Your Ref: OWPC4110
Our Ref: FG/143/14/HH 01-10-2014
Please ask for:
Mr D Sullivan

2 Storey side extension & single storey rear extension
9 Brook Lane Ferring

Thank you for your internet representation made on 18th October 2014 which has been recorded as '**an objection**' with the comments as follows:

PROPOSED ELEVATIONS 1:50

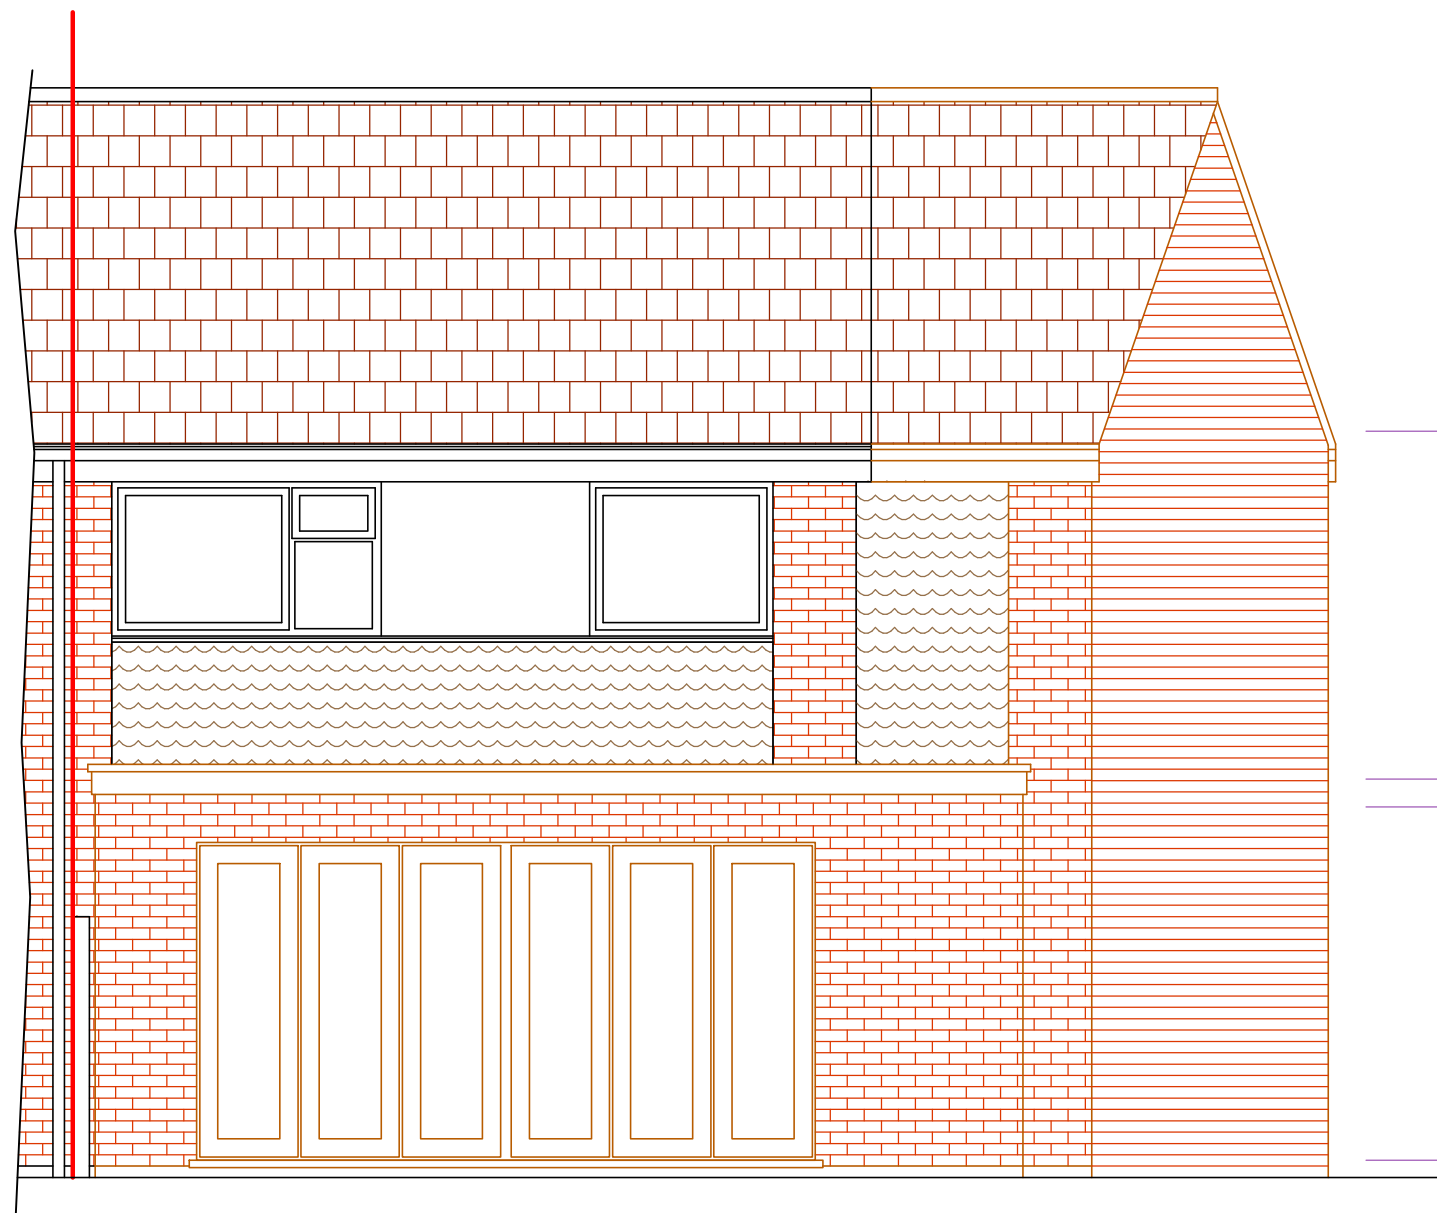
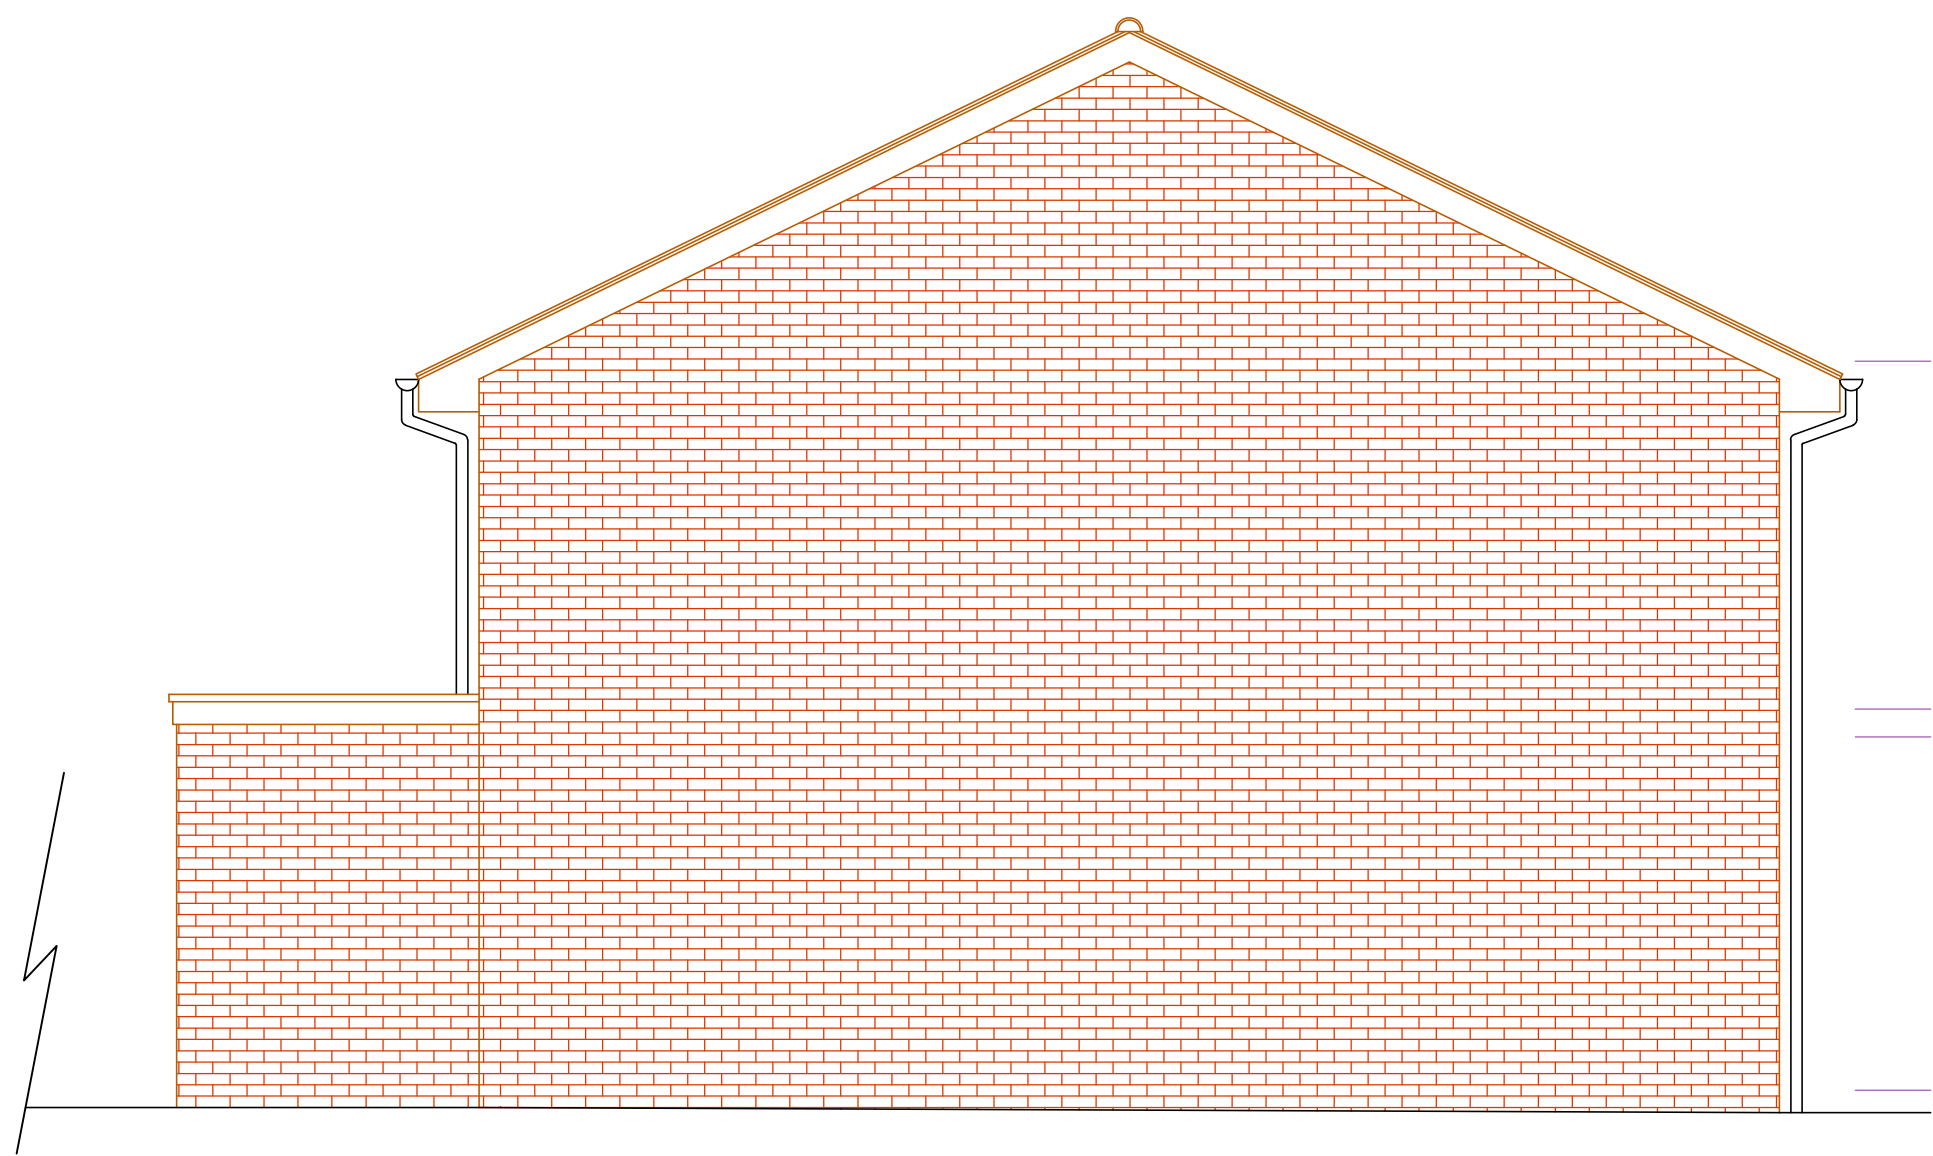
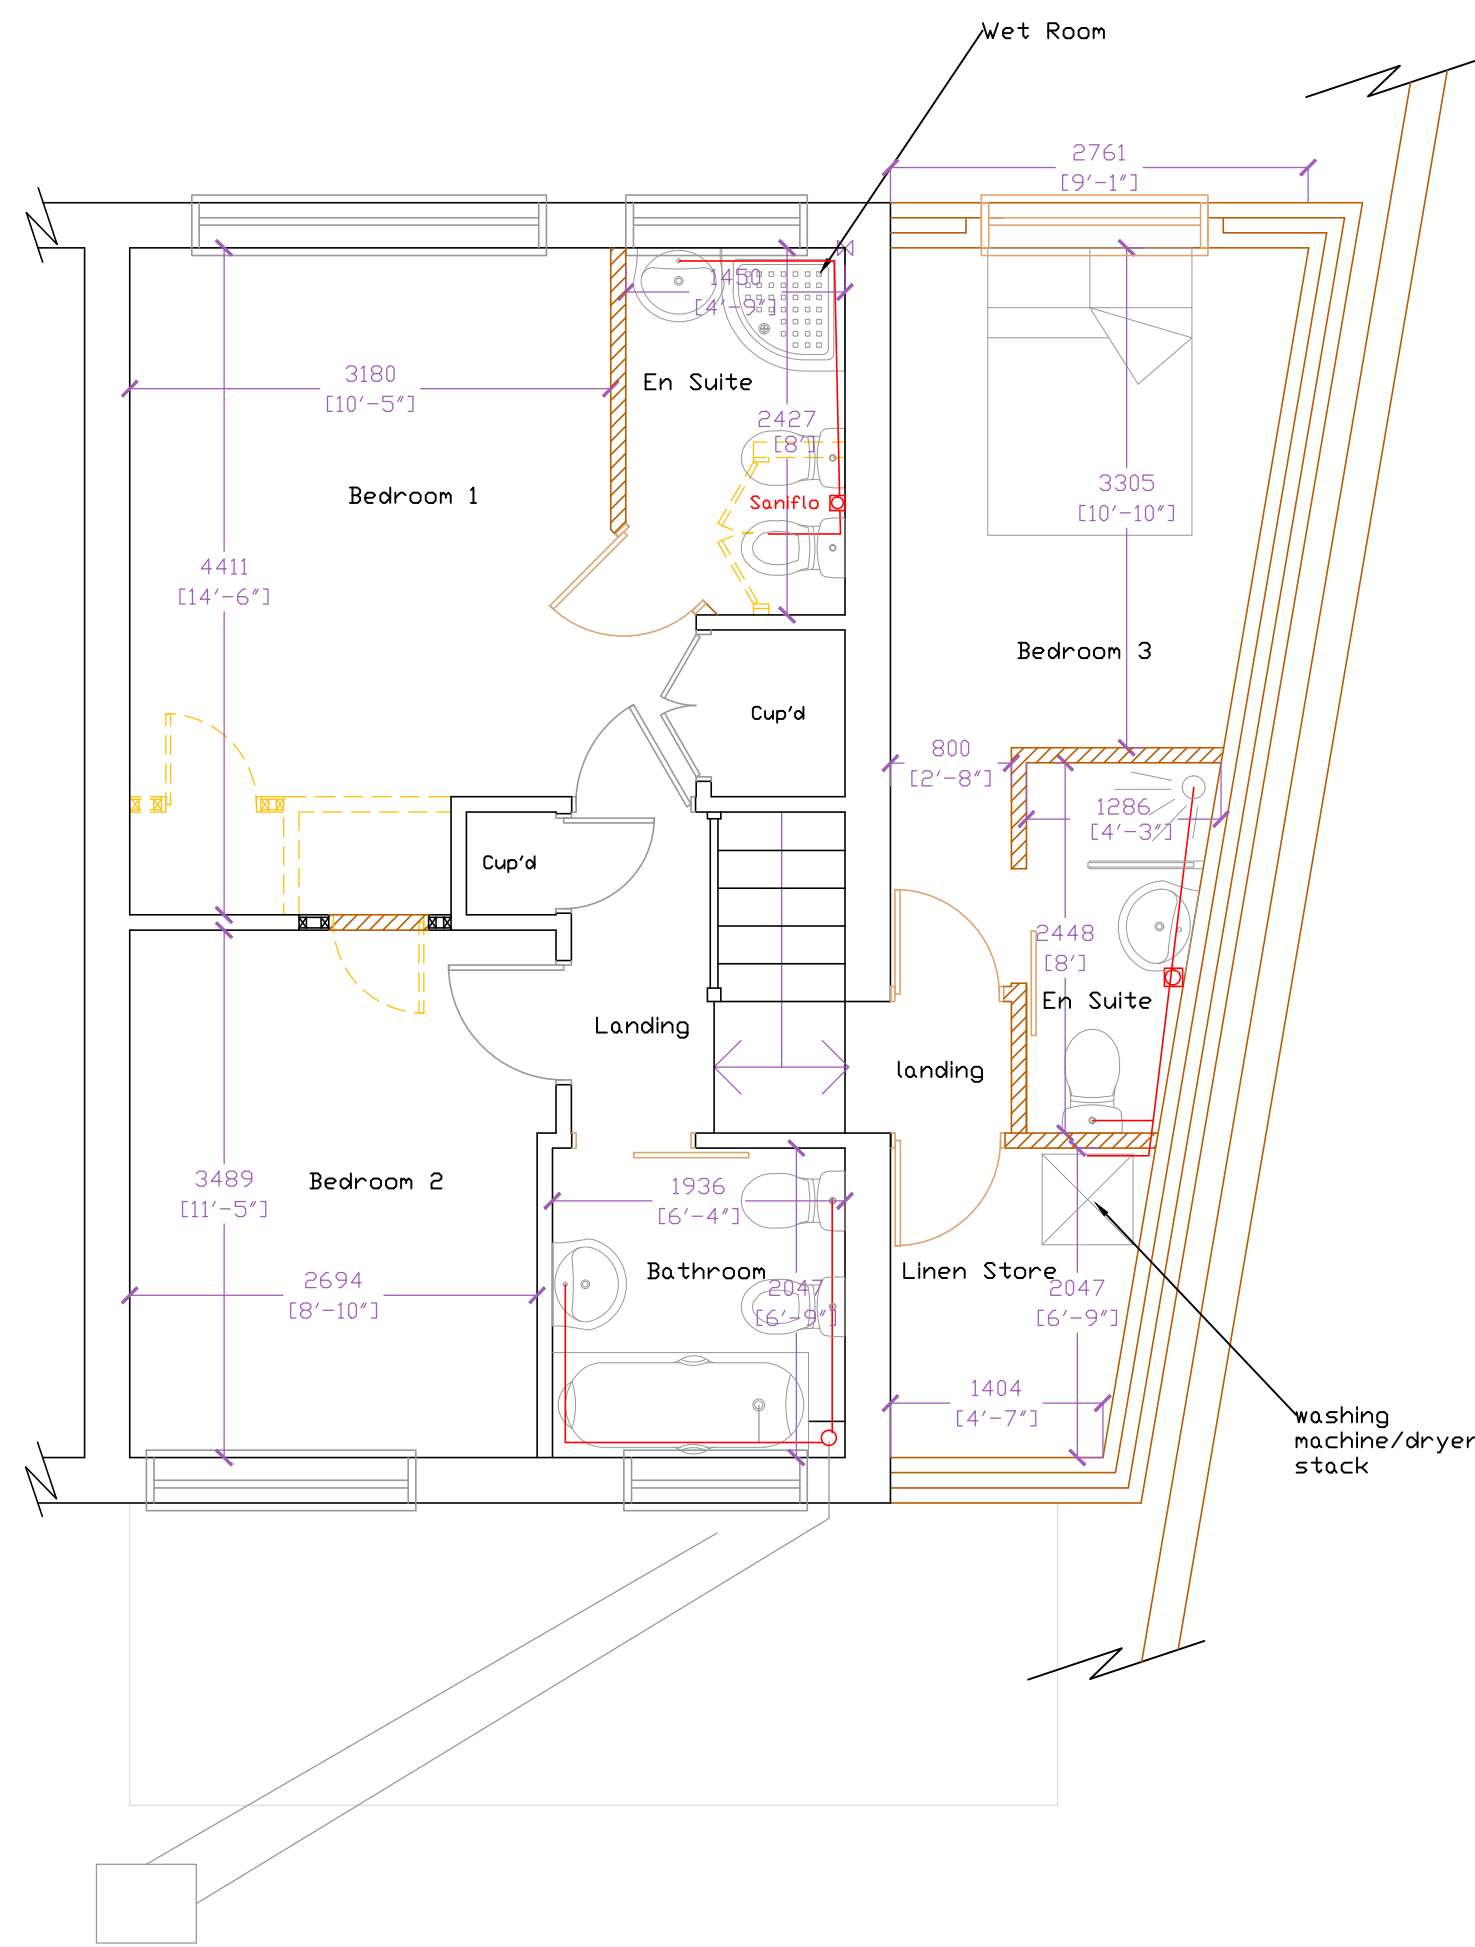
- 1. The look to the front of the terrace will be changed dramatically and we feel this would be detrimental to the overall look of the block which is mirrored in Barbary Lane.*

- 2. The gutters to the block rely on one downpipe which is already at full stretch. Additional guttering should have its own downpipe to prevent overspill and damage to the other properties in the block.*
